February 27, 2001

RE: Shops @25(F17-D46A) - Drainage Re submittal

**RE: Drainage Report for Shops @ 25**  
**Plan dated January 18, 2001**  
**Drainage File # F17/D46A Tract I**  
**Request for Site Development Plan for Building Permit, Building Permit Approval, and**  
**Grading Permit**

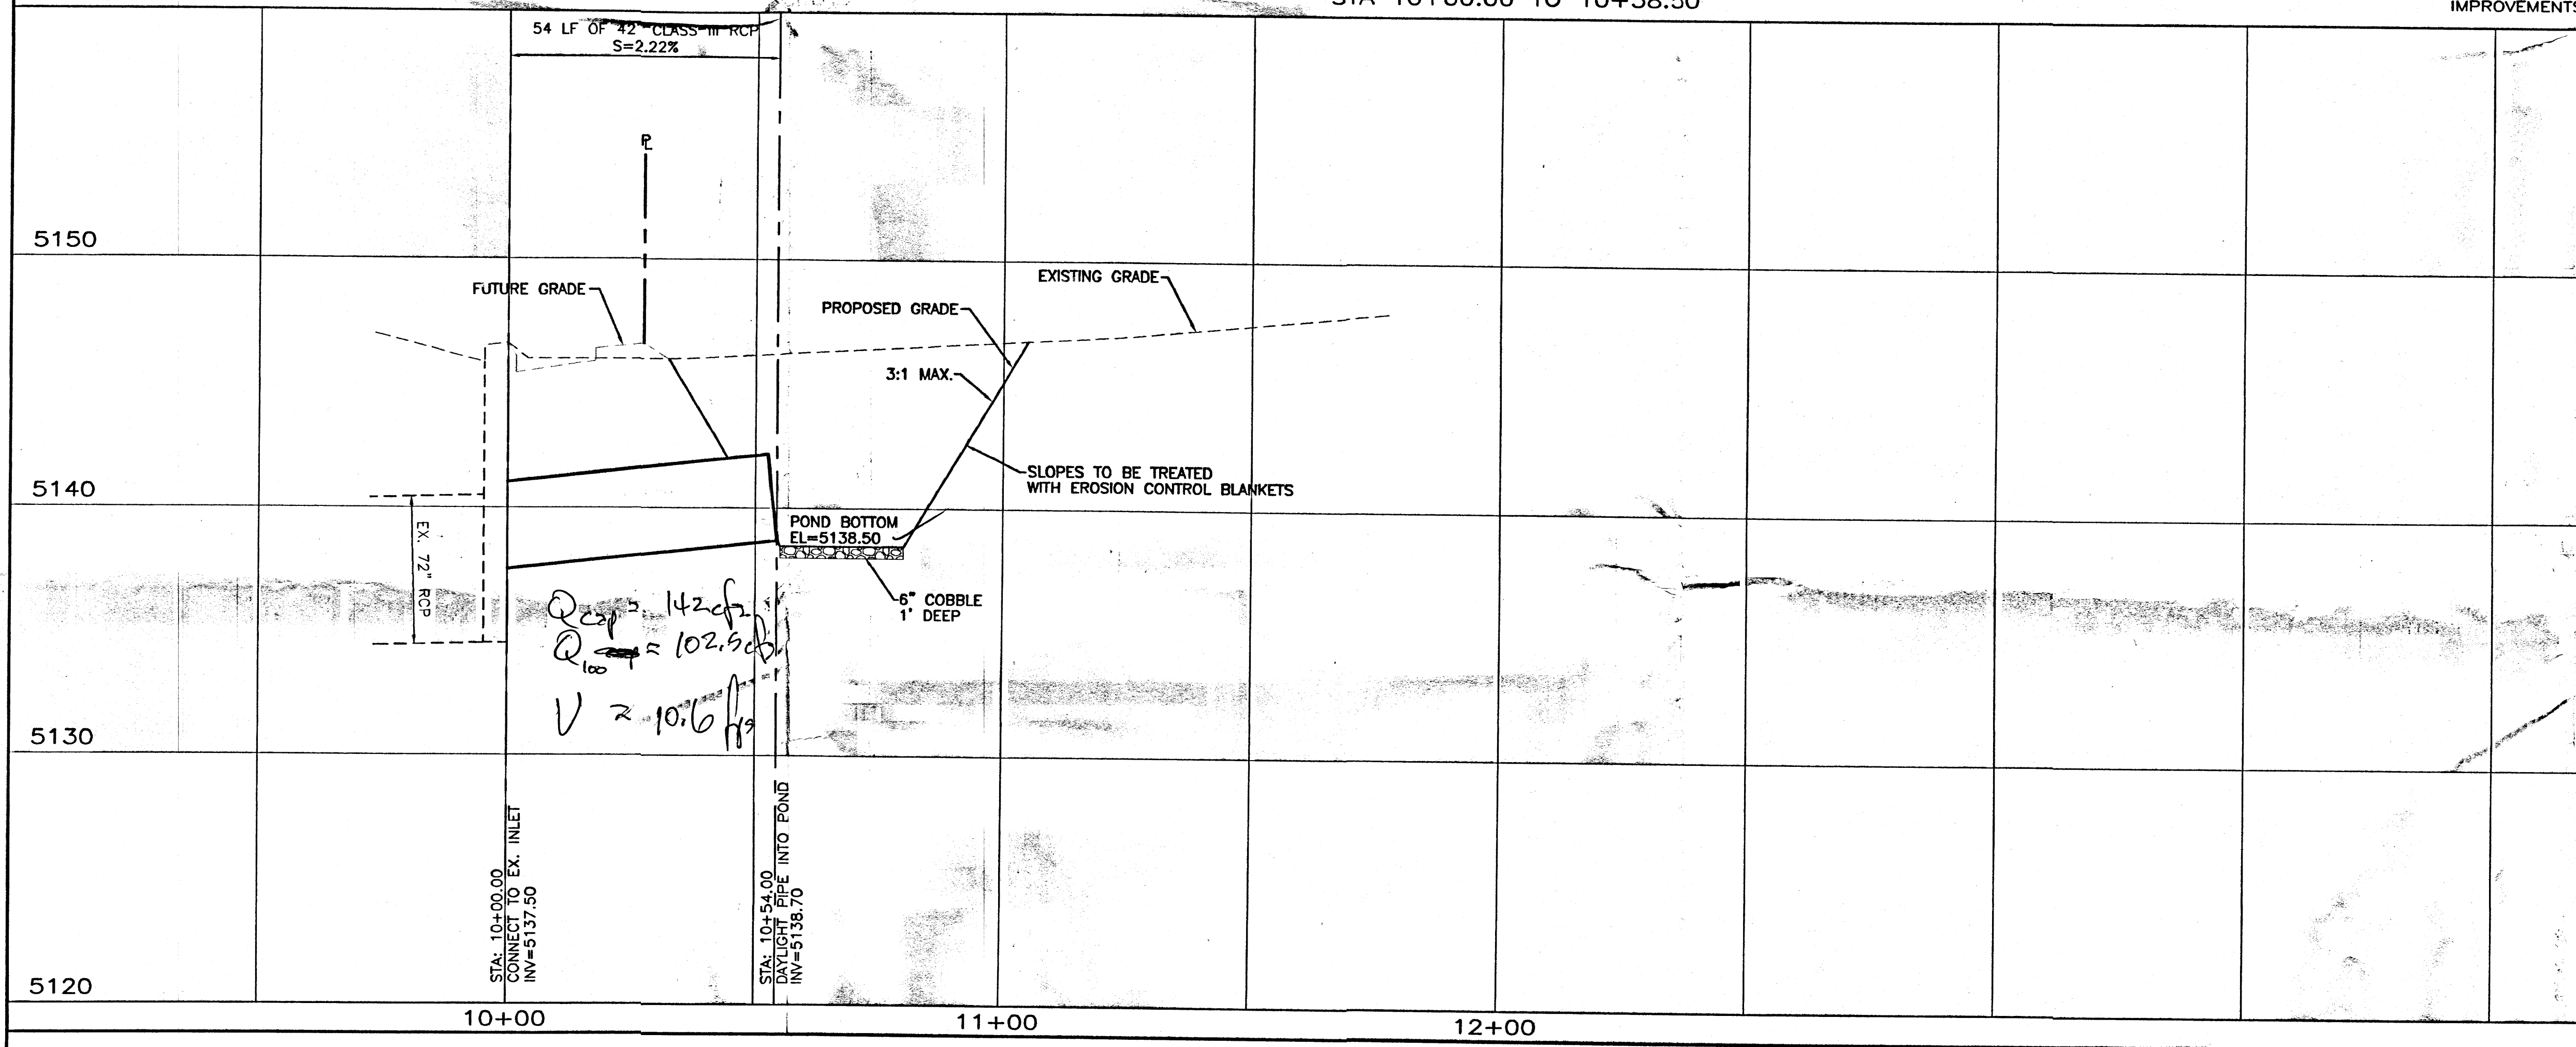
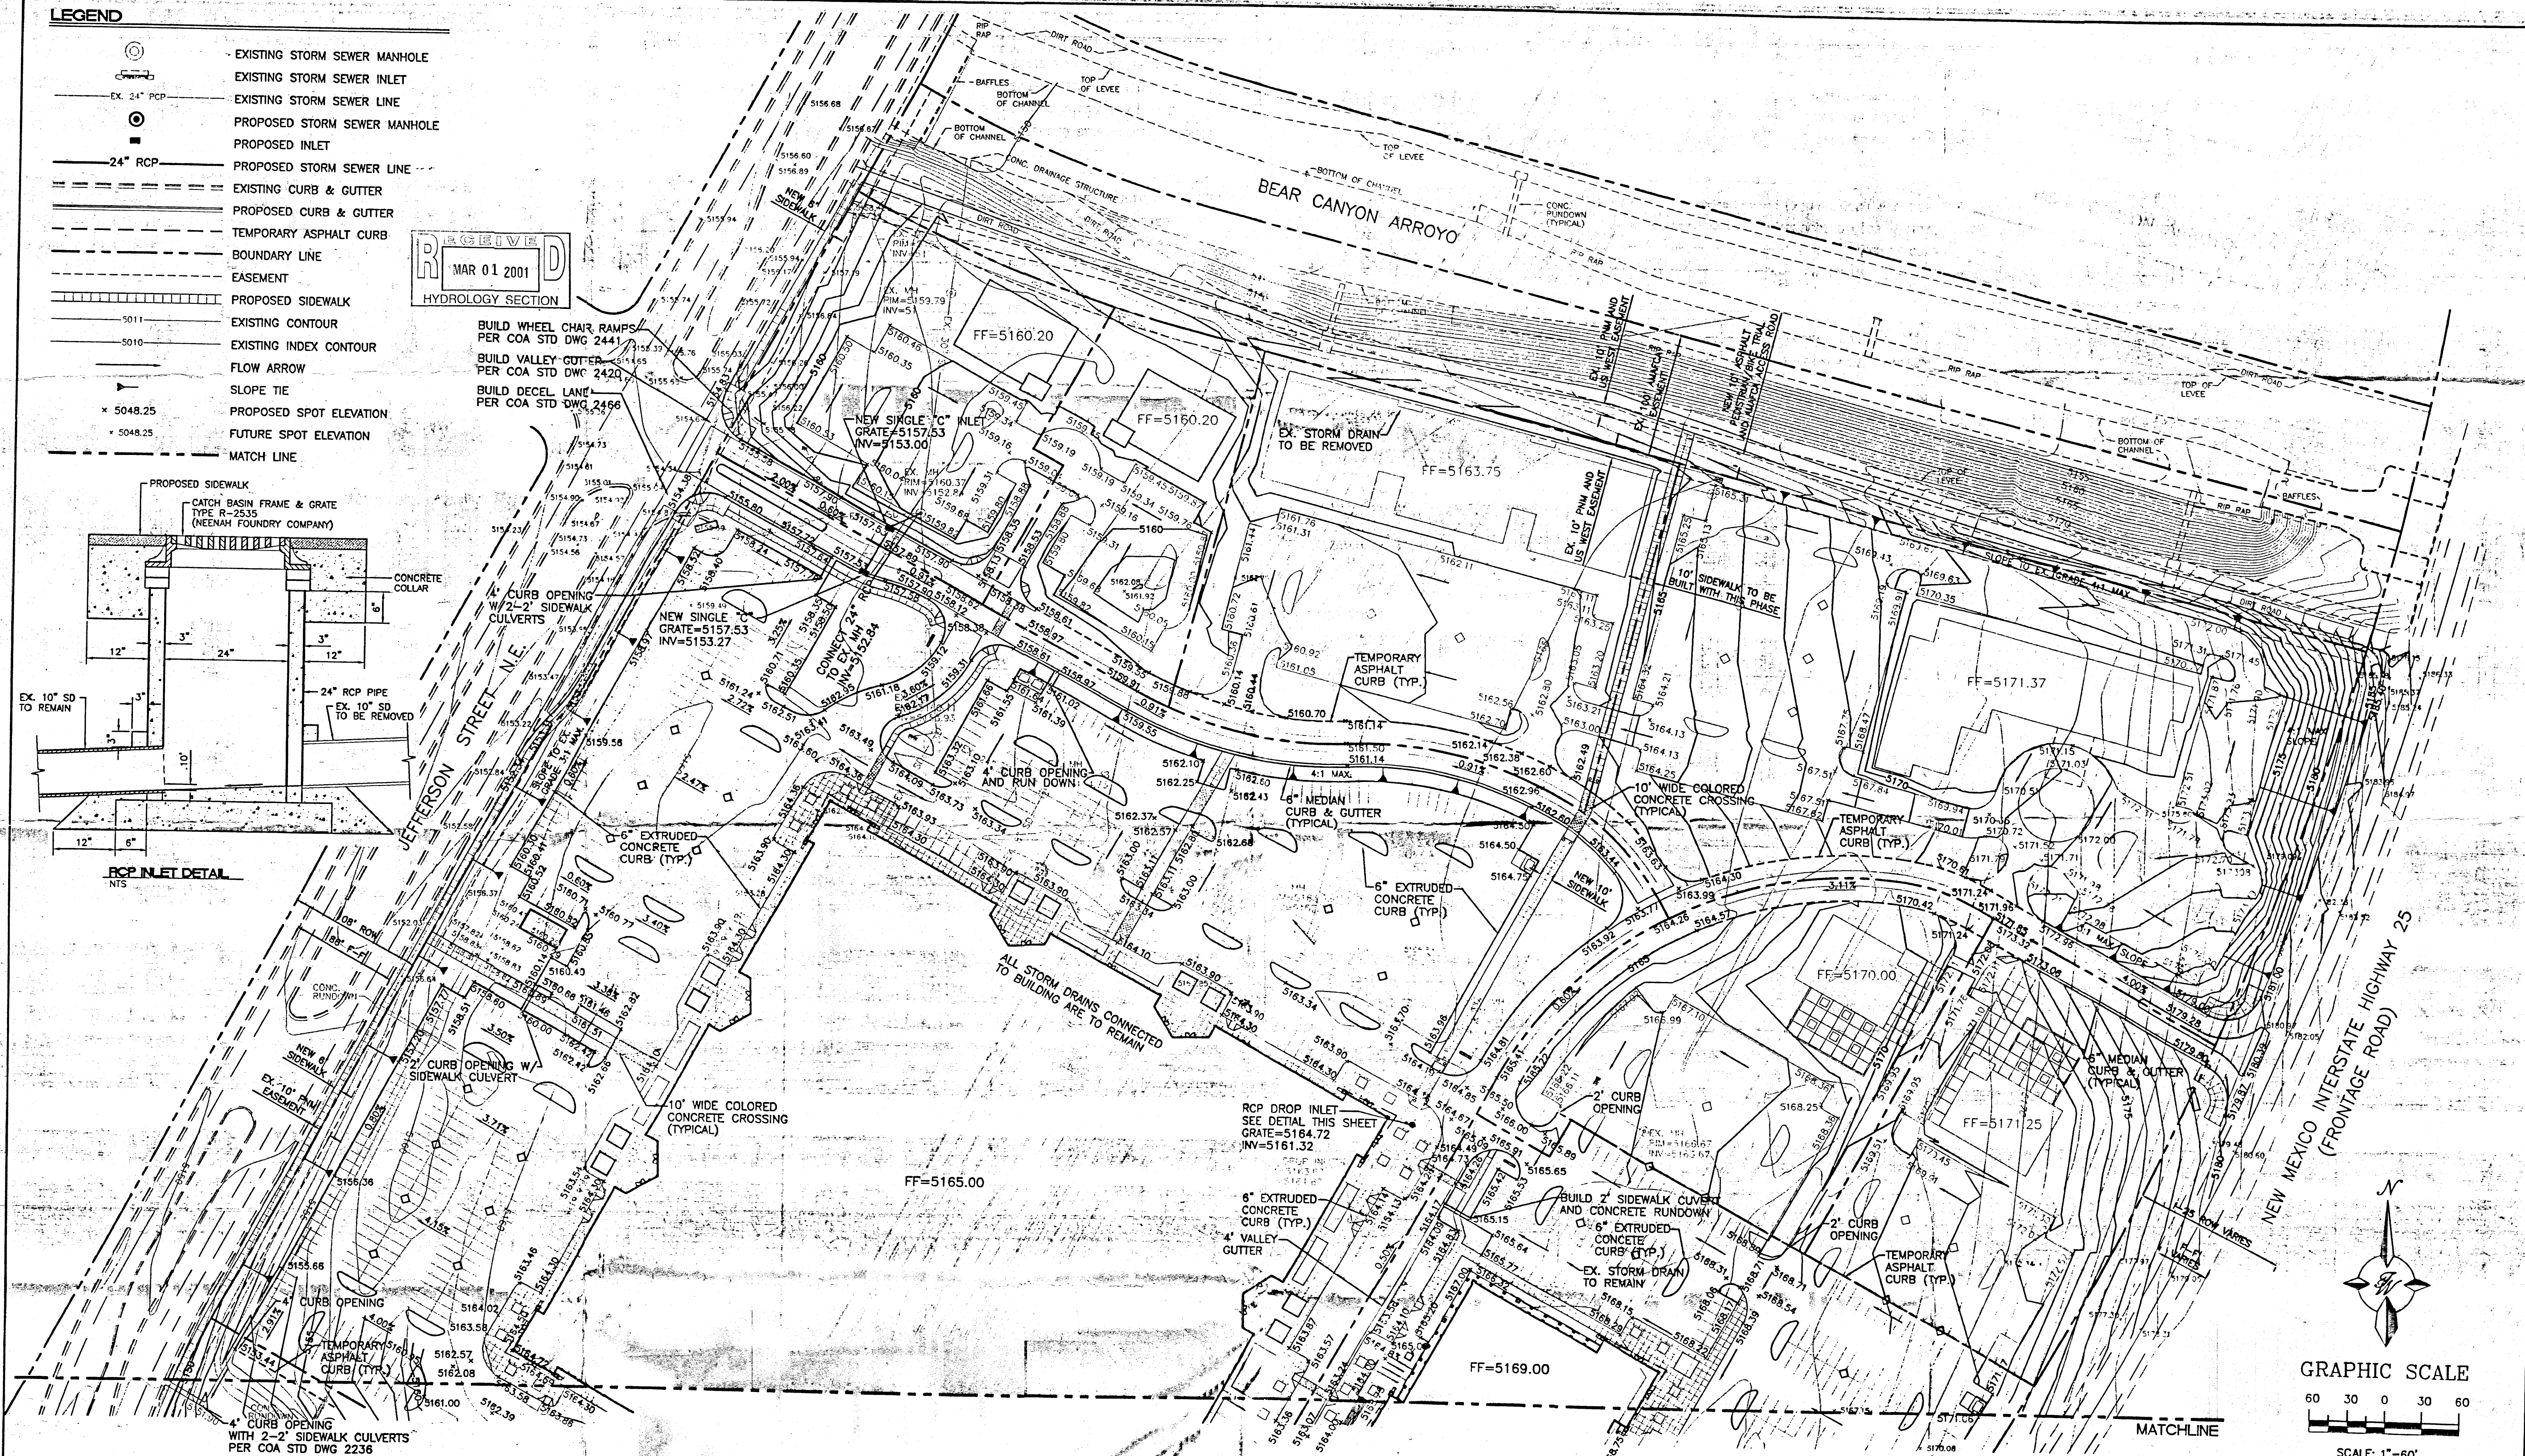
**The design calculations have been added to Appendix A of the revised Drainage Report.** ✓
3. Verification that the 42" Storm Drain will fit in the back of the existing catch basin in Jefferson.

**A cross section of the existing inlets showing the new penetration has been provided on the profile sheet, sheet 2 of 2.** ✓
4. Identify the maintenance responsibilities for the private off-site desiltation ponds and riprap channel. *need*
